JOHN OULTRAM HERITAGE & DESIGN

5th November 2018

Re: Stevenson Library, Scots College Bellevue Hill – Proposed Development (SSD 8922)

We are writing in response to comments received from the NSW Heritage Council in their letter dated 3rd October 2018.

1 Existing Oval / East Elevation Context
 1:1000

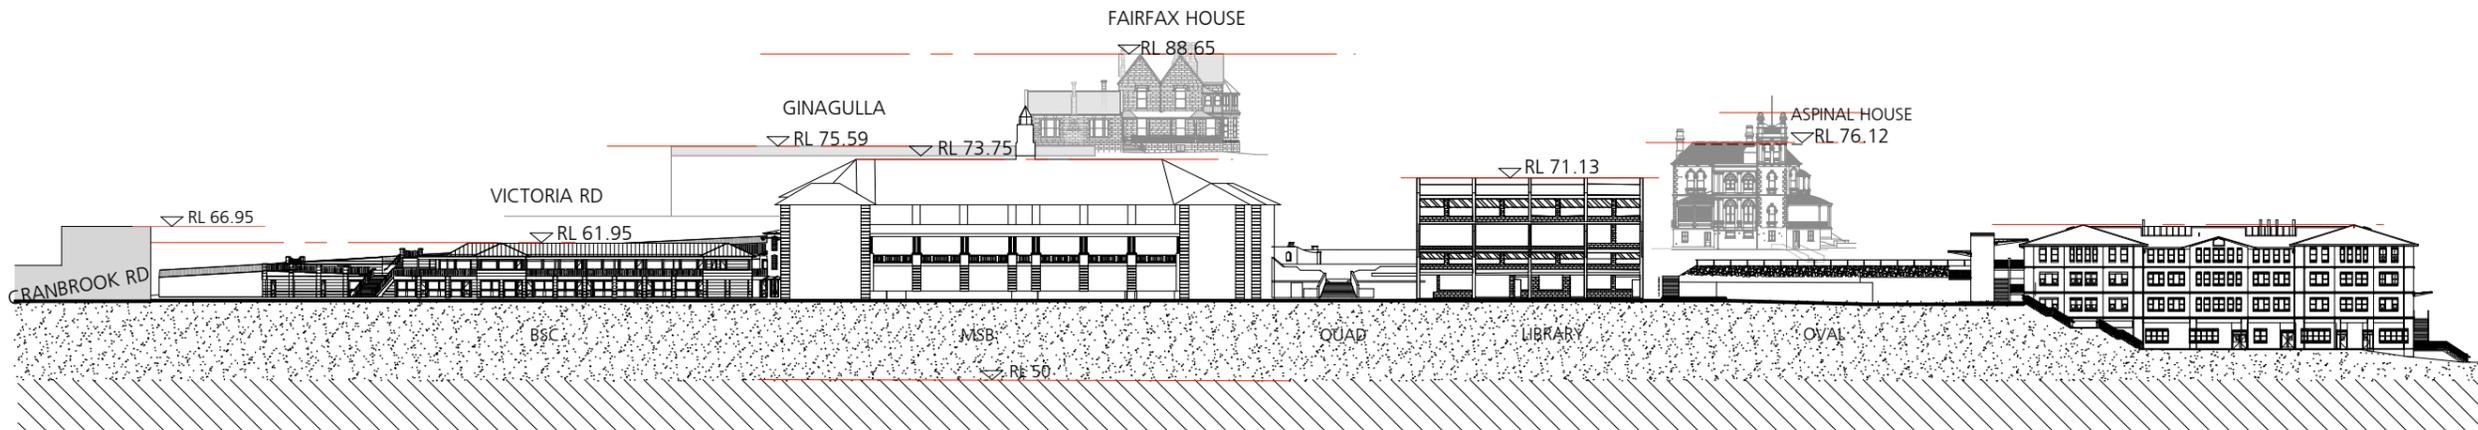
The complicated and more massive roof form with its high turret and dormer protrusions and prominent balustrading to the roof terrace would overshadow and diminish Aspinall House.

The roof design be simplified to avoid visual competition with the (sic) Aspinall House

Response: The library has been designed in the Scottish Baronial style under the guidance of Dr. Alastair Disley, a well known UK based specialist in the style. It is intended to be a true reflection of the style in its layout, massing, detail and roof form.

The building is set at the level of the oval, well below the ground floor of Aspinall house that is set on the higher level of the College along Victoria Road. The primary presentation of Aspinall is to the west and north though it has a heavily decorated facade and tower to the oval. The building has very robust elevations and the library will not be visible in views from Victoria Road as it is set at the ridge height of Aspinall House.

The library is set to the southwest following the footprint of the existing library and the replacement building will have a similar relationship to Aspinall House. From the oval there will be no greater intrusion into views to Aspinall than currently exist and views to Aspinall House from the east and northeast will be retained.

The simpler roof form to Aspinall House reflects its Victorian origins and we can see no merit in a simpler roof form to the library as this will considerably dilute the design intent and remove the roof features that are reflective of the style and that are intended to be seen in outline against the sky.

We consider it better to provide a faithful representation of the style rather than adopt a less complex roof form and the current design is a very well considered representation of the style.
